Our ref: NO/2012/104433/02-L01

Your ref: 3/2012/0876

Date: 07 December 2012

**DEVELOPMENT OF 3 HOUSES LAND OFF VICTORIA TERRACE, MELLOR
BROOK, BLACKBURN**

land at Mill Cottage proposed site plan

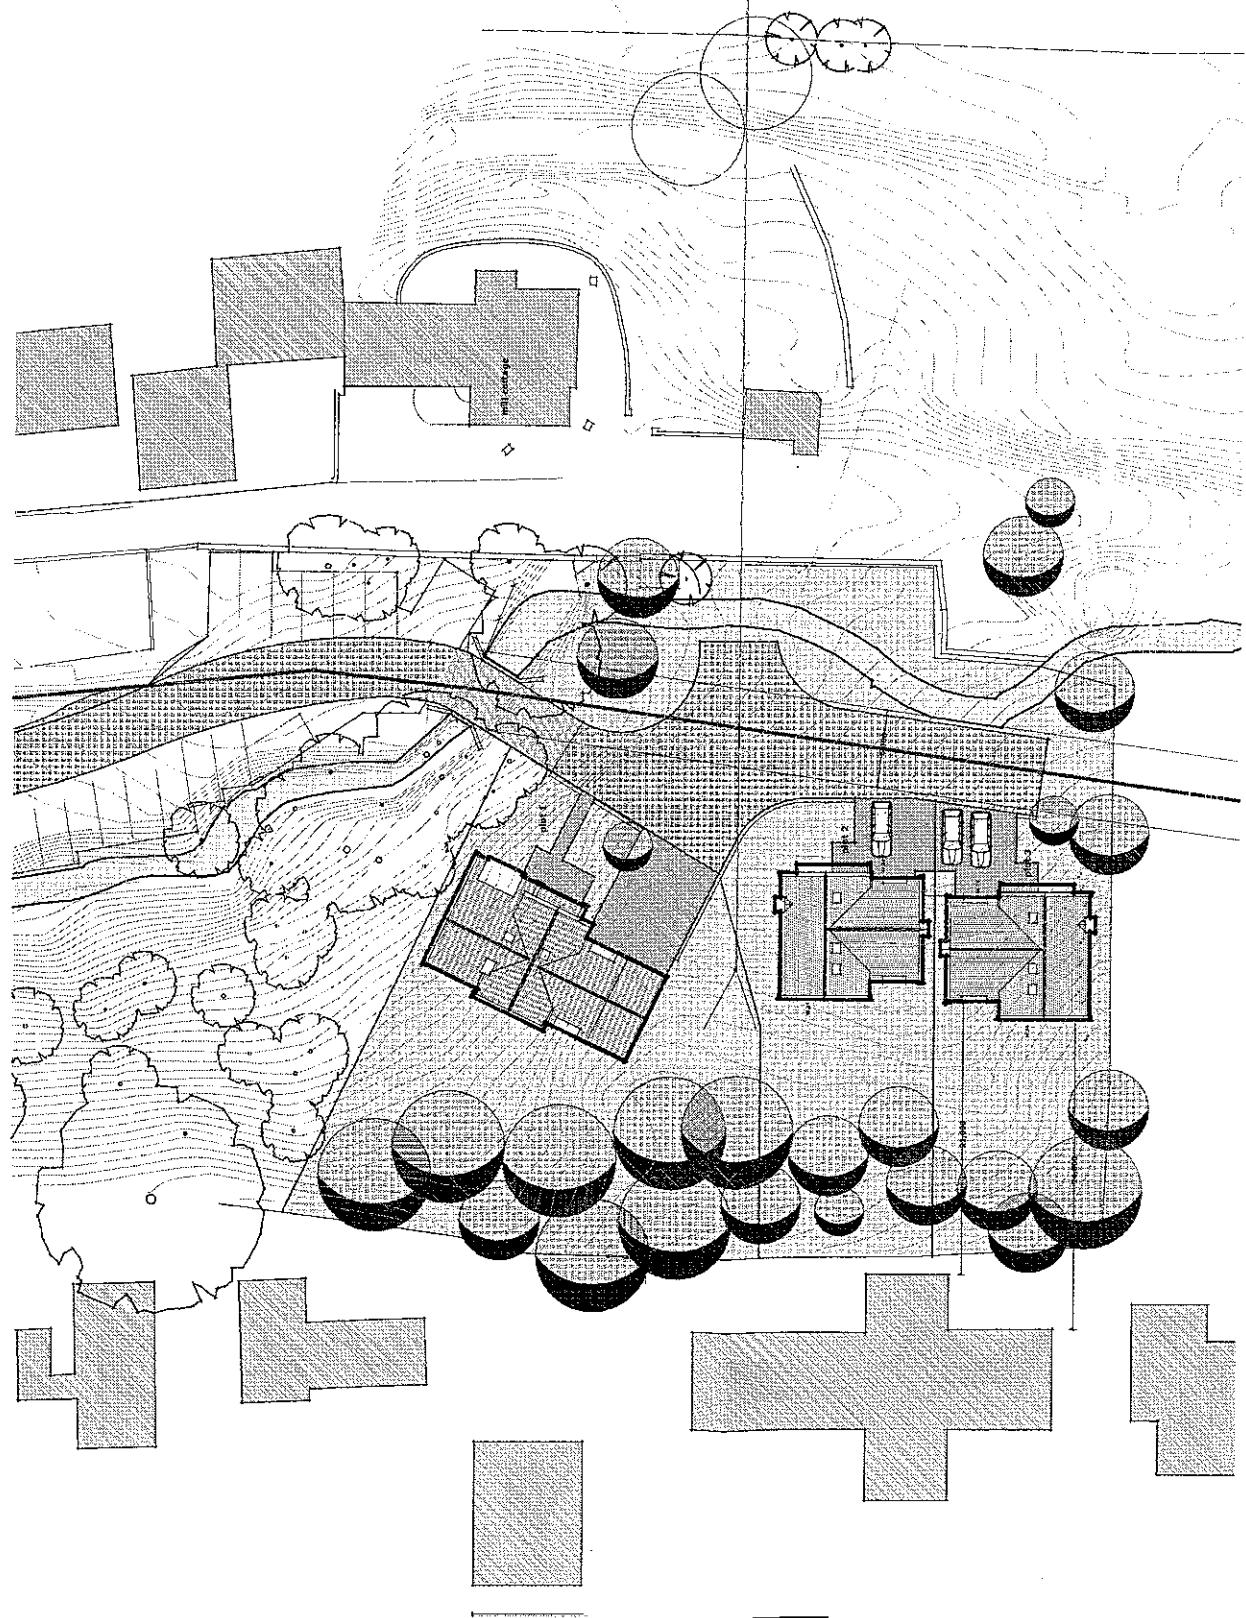
The proposal will only be acceptable if a planning condition is included requiring a working method statement to be provided. The method statement must provide detail on all the deculverting works and the creation of compensatory habitat at the site.

Details of the timing of works, methods for creating all channels, bankside and water margin works, machinery to be used (including location and storage of plant, materials and fuel, access routes, access to banks etc) and how areas of ecological sensitivity and importance shall be protected should be incorporated in the scheme.

The construction phase of any proposed development affecting the channel and banks of the watercourse poses significant risks of damage to water dependent species and habitats. We would like the method statement to detail the length of the proposed deculverting, the design of the new channel to be opened up and what will happen to the excavated material.

No development shall take place until a working method statement to cover all the deculverting works and the creation of compensatory habitat is submitted to and agreed in writing by the local planning authority. Thereafter the development shall be carried out in accordance with the approved scheme subject to any subsequent amendments or modifications requested in writing with the local planning authority.
